Department of Transportation

June 20, 2019

RE: Ellicott Town Center 2019 - Final Plat Extension SF1825
Ellicott Town Center 2019 - Commercial Rezone CS192
Ellicott Town Center 2019 - Commercial Replat SF1910

The Colorado Department of Transportation has reviewed for the above mentioned Filing No. 1. Of the 98 residential lots on 288-acres of parks, open spaces, commercial and industrial for the Ellicott Town Center, Final Plat Extension SF1825, Rezone CS192 and Commercial Replat SF1910 of this development located south of SH 94 and west of the existing Log Road in El Paso County. Comments are as follows:

SHEET:
C1.02

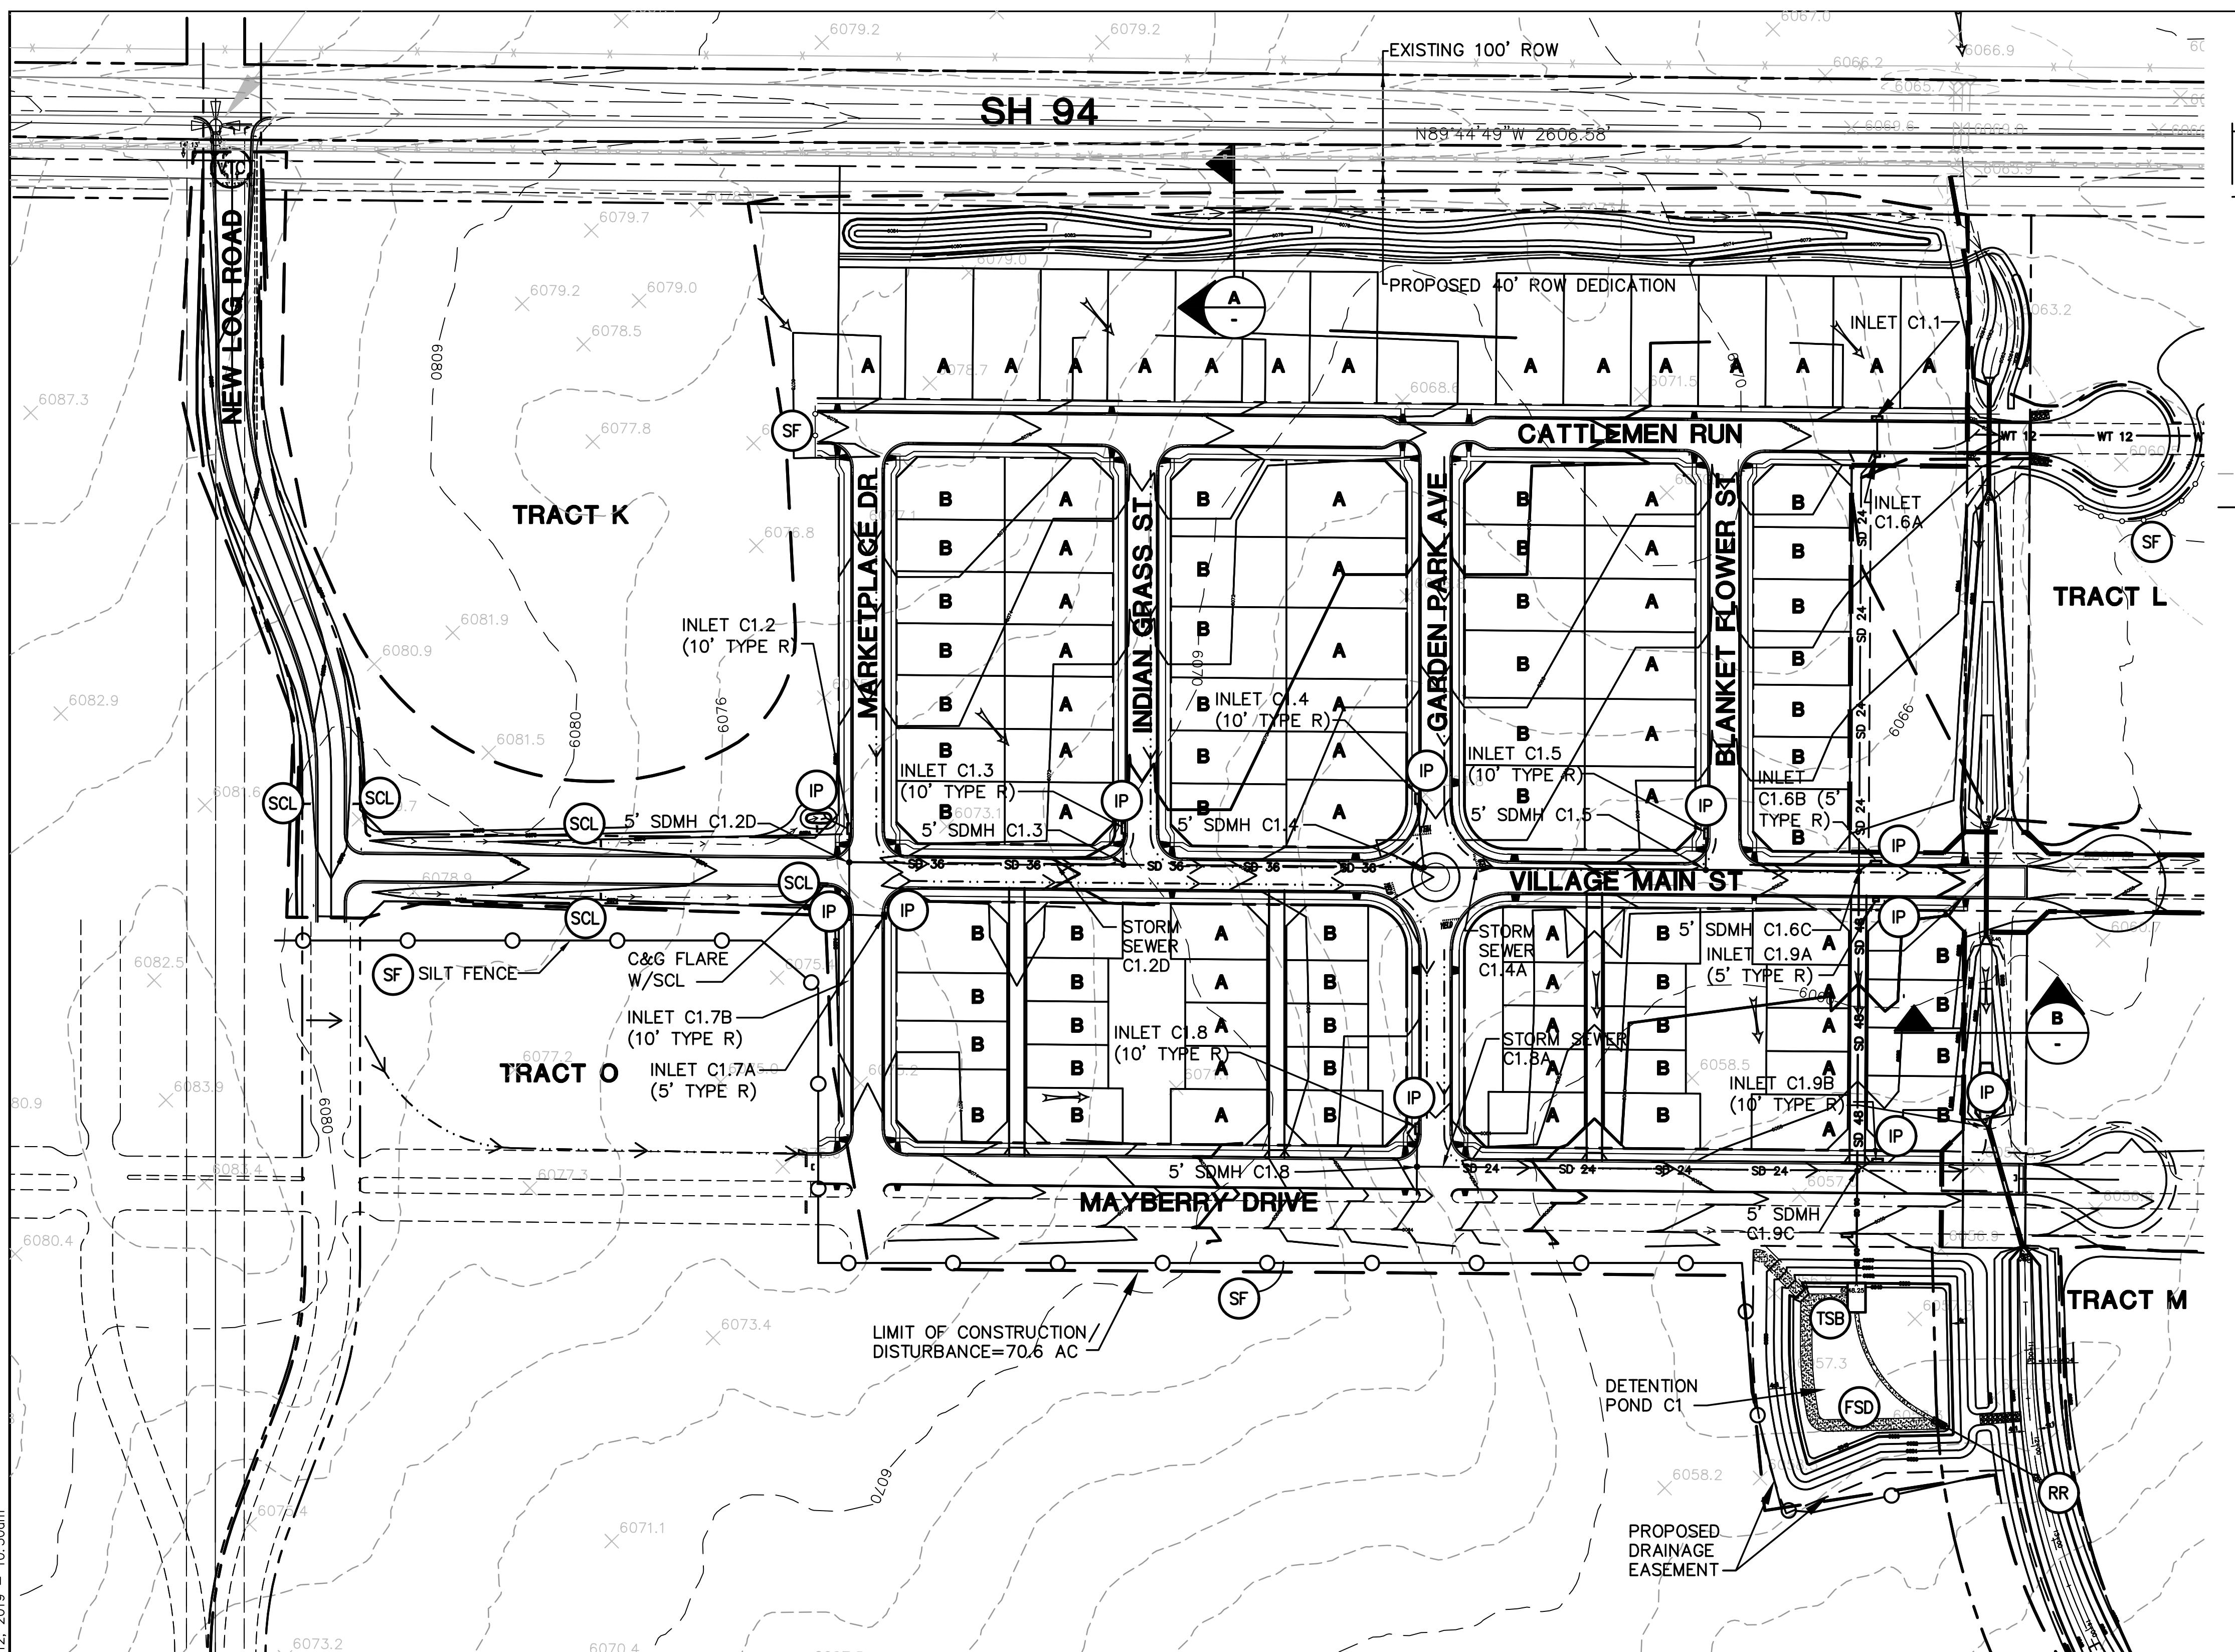
- ◇ *The inserted drawing C1.02 (Filing No. 1 Grading and Erosion Control Plan) shows a 6' tall berm along SH 94 just south of CDOT ROW. The history flow pattern of the site is from NW to SE. If the developer wants to use the berm to block the flow to the south, grading work needs to be done at the east end of the berm and near the proposed ditch. Otherwise, water will pond on CDOT ROW. The existing 30" CMP culvert shall be*

extended and erosion control measures taken at the end of the culvert. The drainage plan did not show all of the abovementioned drainage items.

- ◇ *The easterly existing 30" CMP culverts need to be extended also. The report and plan did not show how to convey the water from this culvert.*
- ◇ *These items shall be addressed by the engineer prior to CDOT approval of the drainage report.*
